Gate Burton Issue Specific Hearing (ISH) 2 - Draft DCO

7000 Acres is an interested party in the DCO Examination for the Gate Burton Solar Project and three additional solar NSIPs in the local area.

TPO and Hedgerow Removal Plan
Document Reference: EN010131/APP/3.8
January 2023

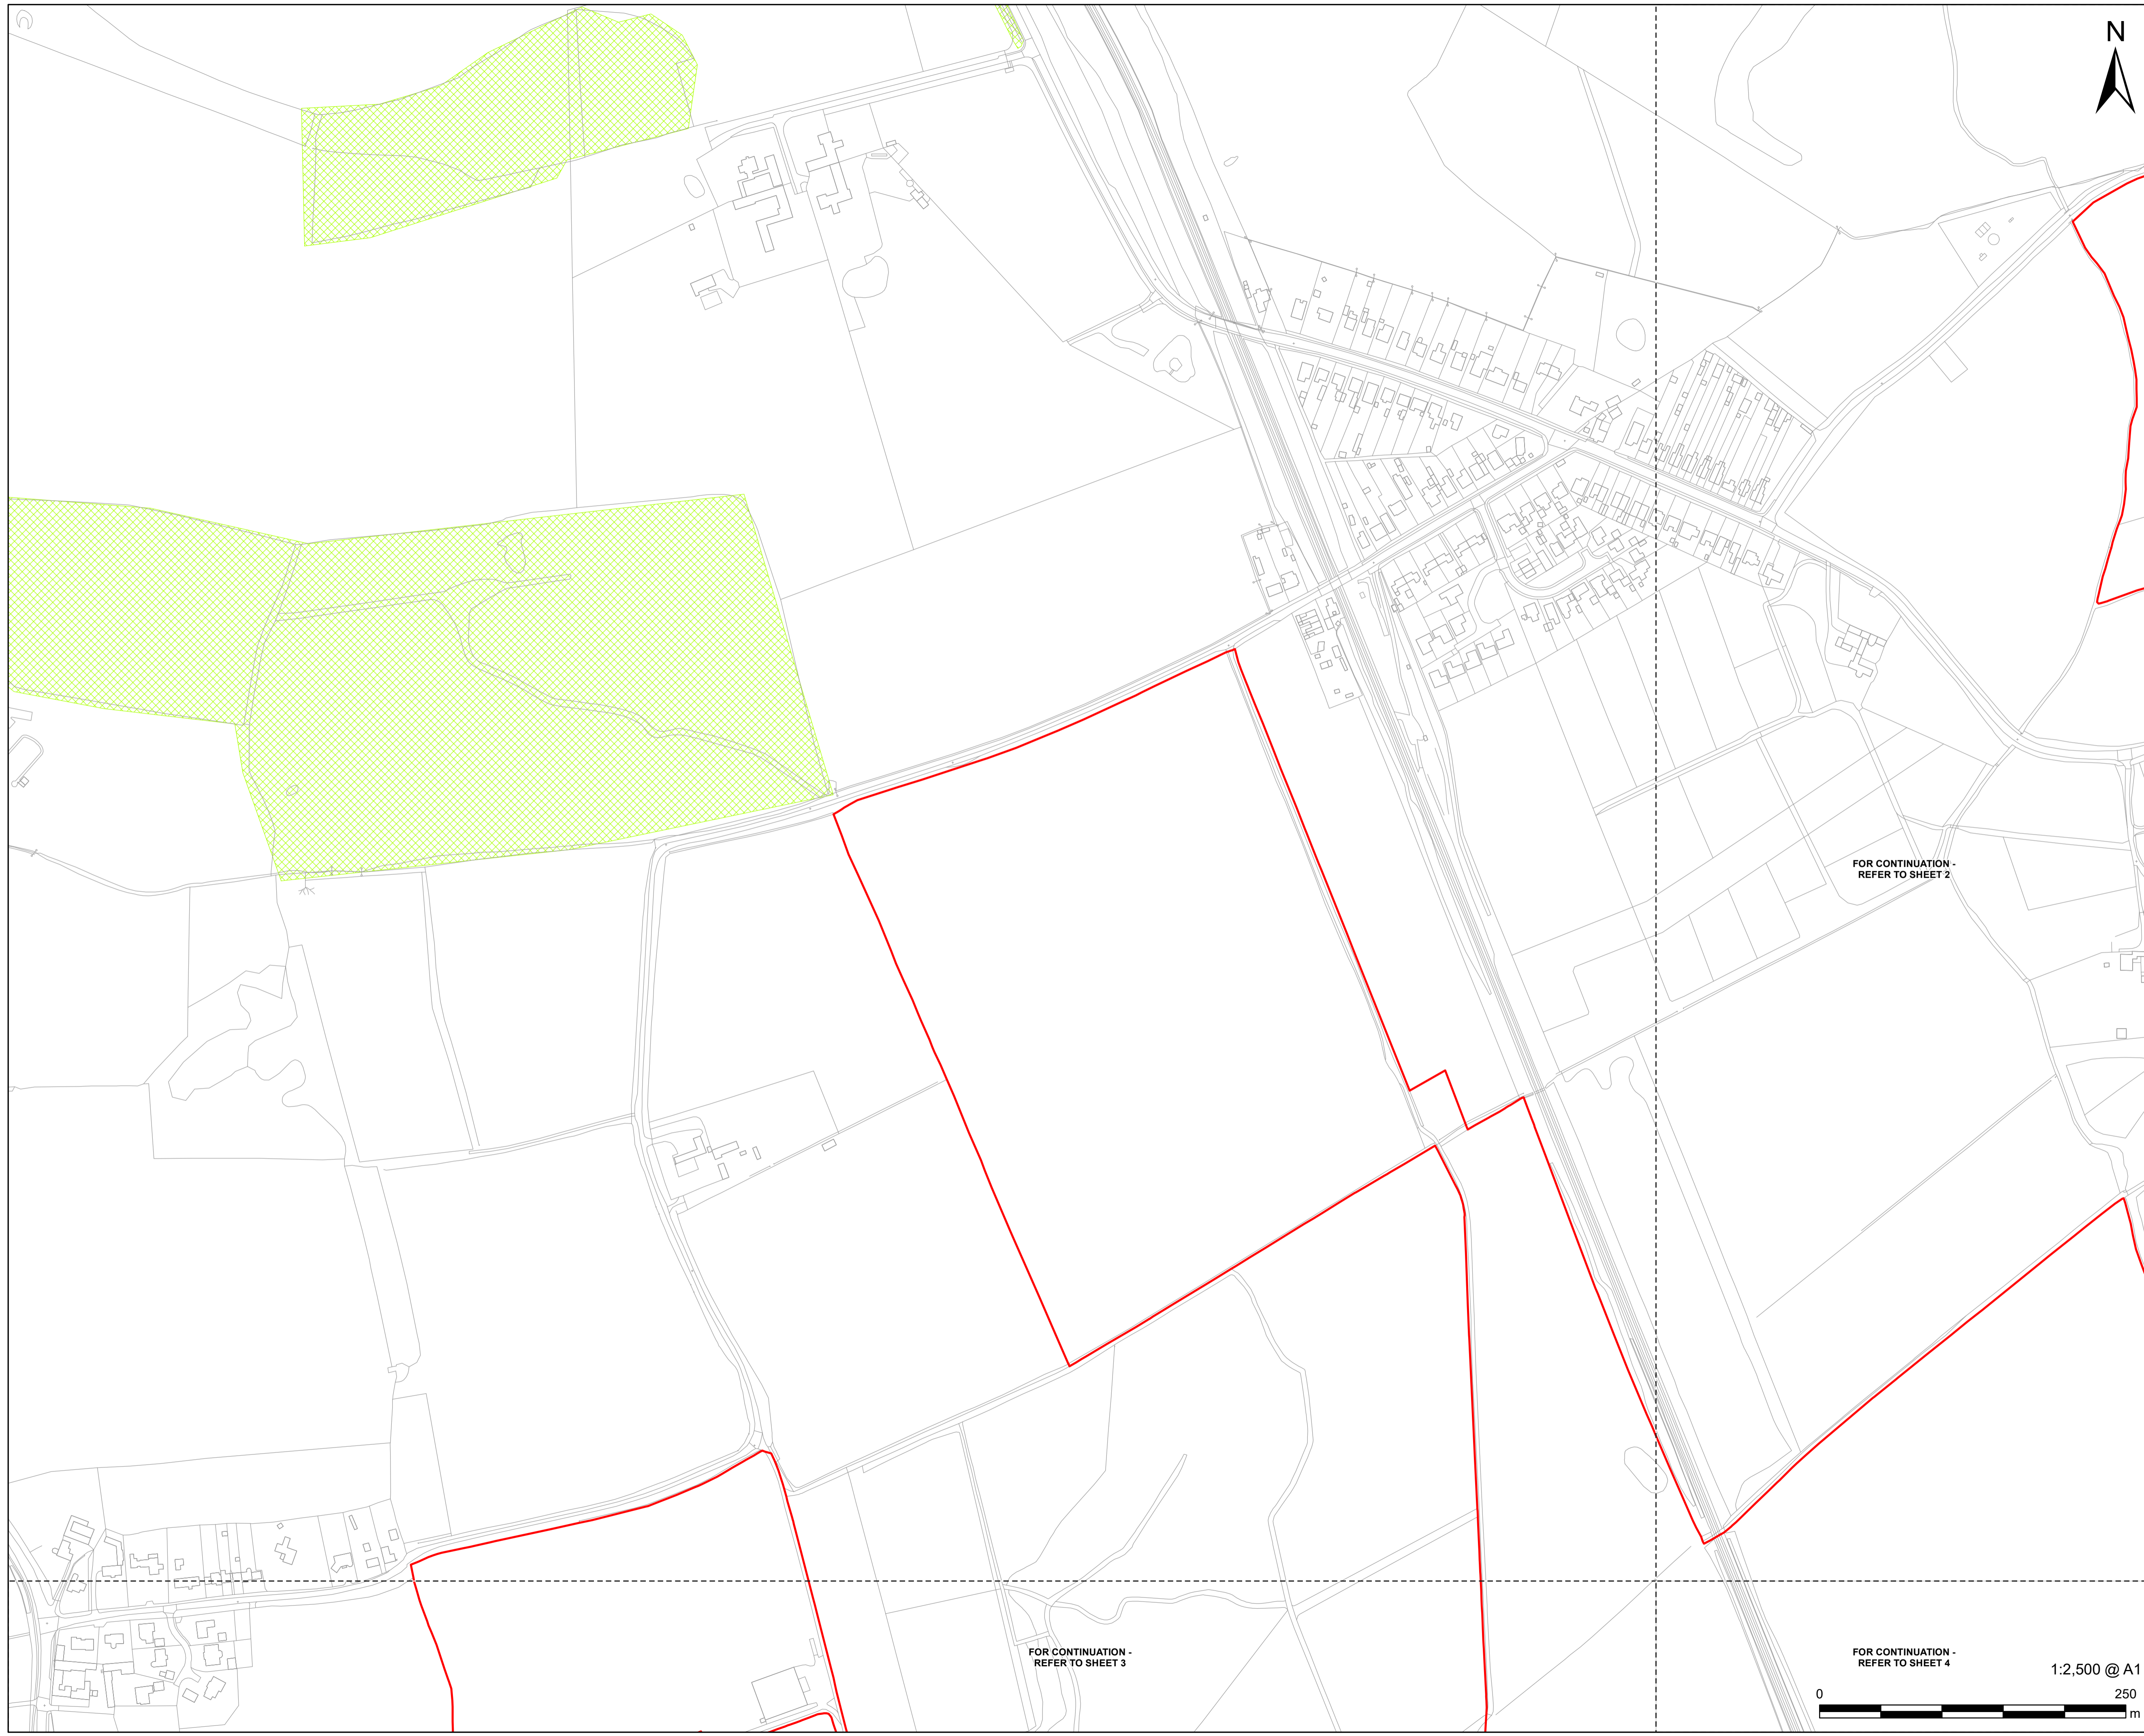
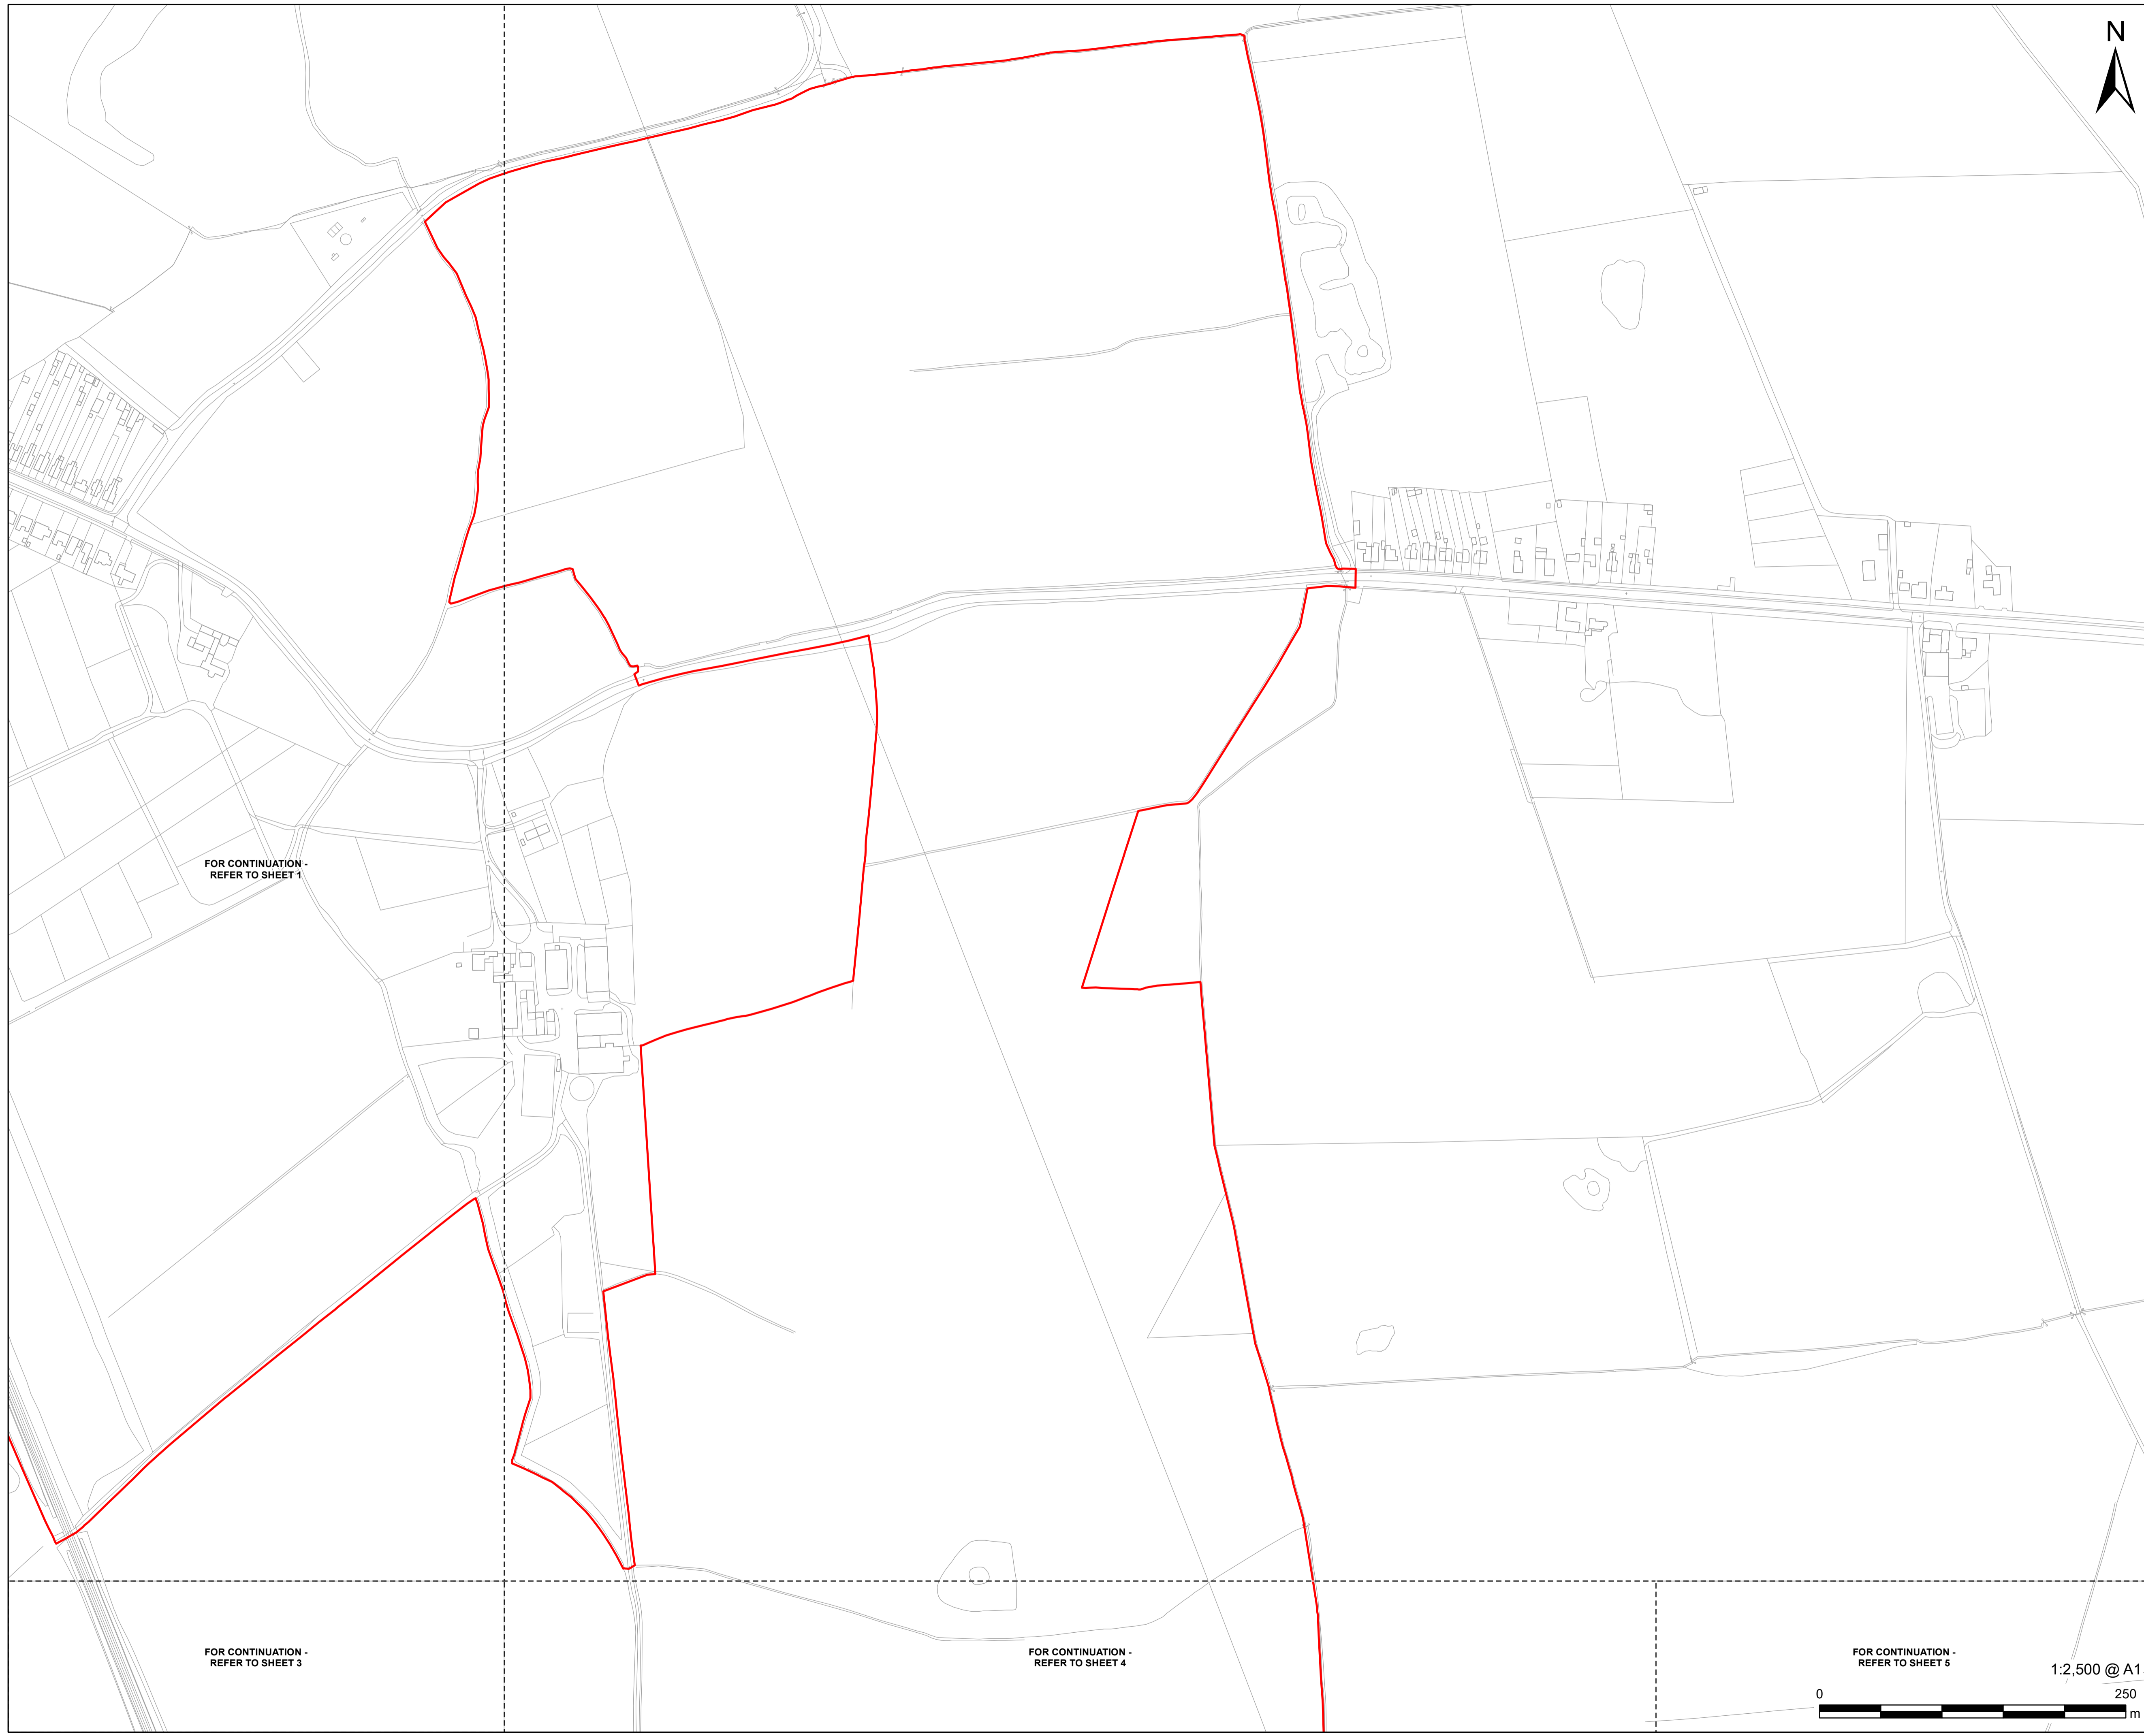
- The Applicant has failed to explain why in Requirements 38 and 39 they should have the ability to fell any tree or remove any hedge they wish. The current wording of the dDCO would allow the Applicant to remove all hedgerows and trees they believe to be necessary without any checks and balances. In the opinion of 7000 Acres, the dDCO should be revised to state that any lopping, pruning, felling or removal of hedgerows, trees or shrubs should be in accordance with the Landscape and Ecological Management Plan.
